Our Ref: BE/148/25/NMA

Non-material amendment following the grant of BE/73/25/S73 for change of specific grass to rear gardens.

Land to the East of Shripney Road Shripney PO22 9NW

Detailed Planting Plan 1 of 3

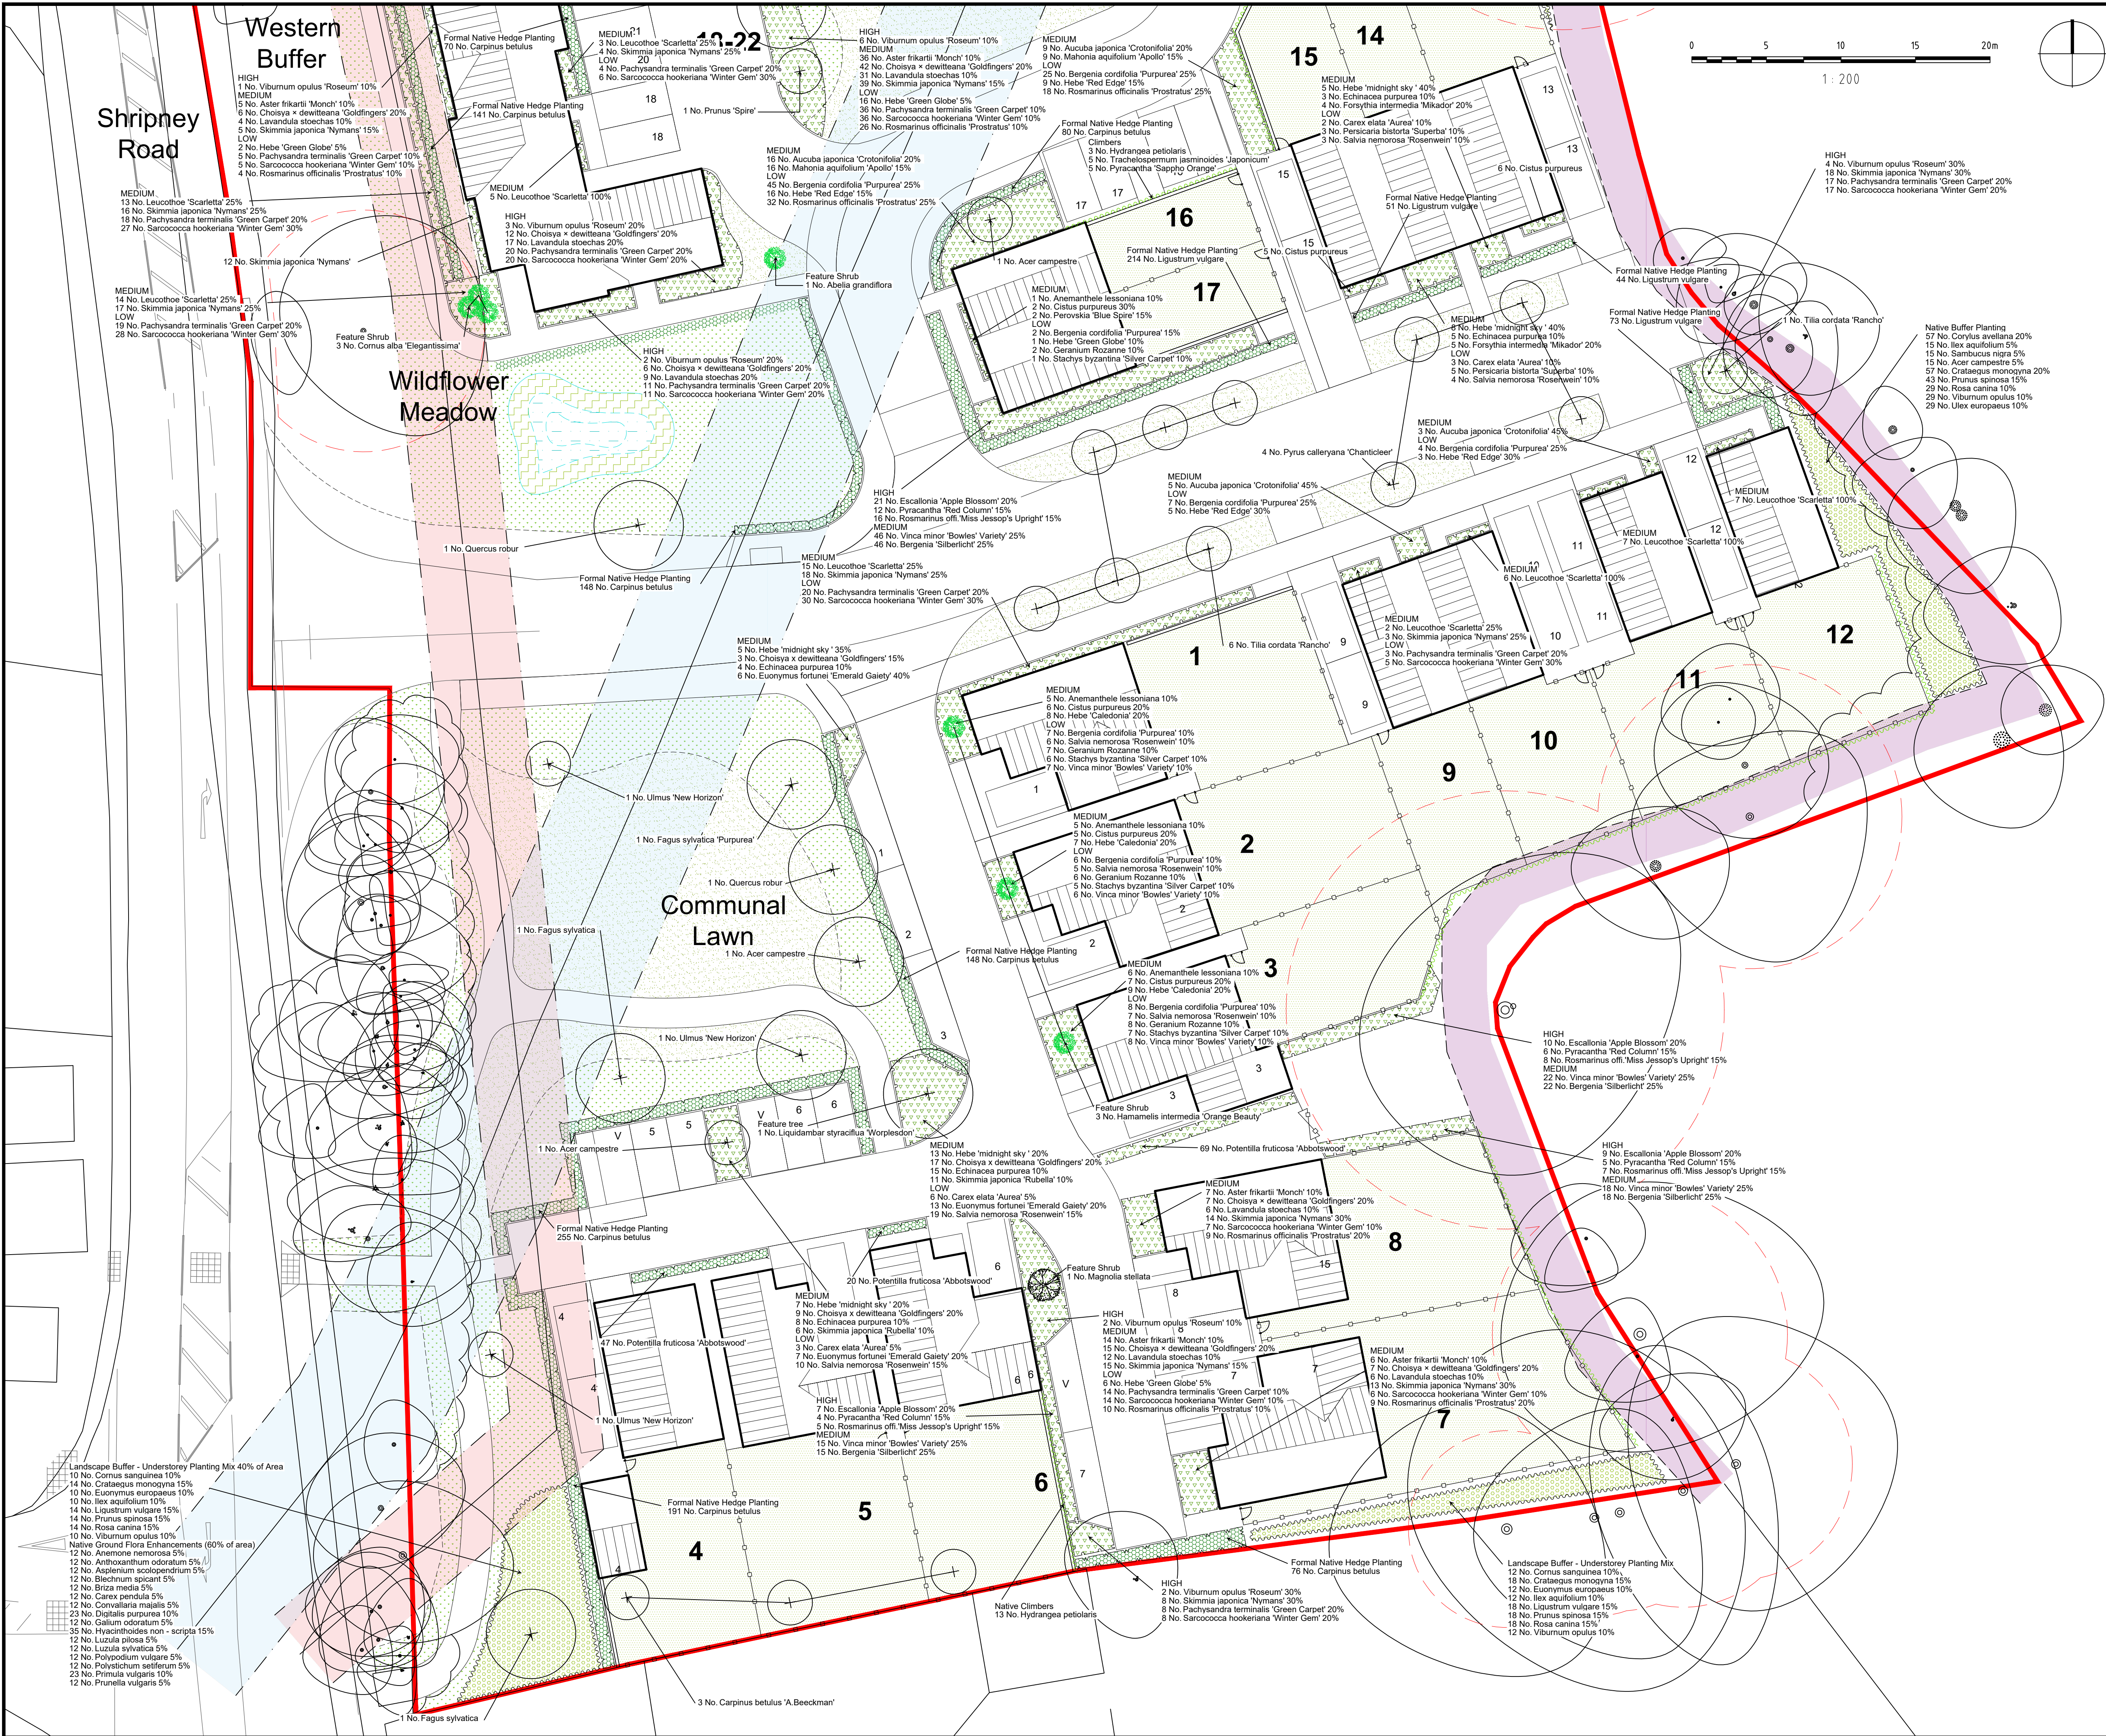
I refer to your recent application for a Non Material Minor Amendment. You propose to change the specification of grass to the rear gardens of properties from "Proposed lawn to back gardens - Naturescape N14 Flowering Lawn Mixture or similar" (as approved) to "Proposed amenity lawn to back gardens using high quality turf - Rowlan Medallion or similar" (as proposed). This is because a flowering lawn mixture in rear gardens creates maintenance issues for the homeowners.

The proposed change is clearly a minor alteration that does not conflict with the above guidance and does not adversely affect the quality of the development as a whole. There is no impact on statutory Biodiversity Net Gain as the application was approved prior to its introduction. The loss of the flowering element of the lawn will impact on local biodiversity but not to the extent that this cannot be agreed as an NMA.

The changes can be accepted as an NMA under section 96A of the Town and Country Planning Act 1990. The following plans are therefore accepted as amendments to condition 1

- DD598L03 Rev C Detailed Planting Plan 1 of 3 (REVISED).
- DD598L04 Rev C Detailed Planting Plan 2 of 3 (REVISED).
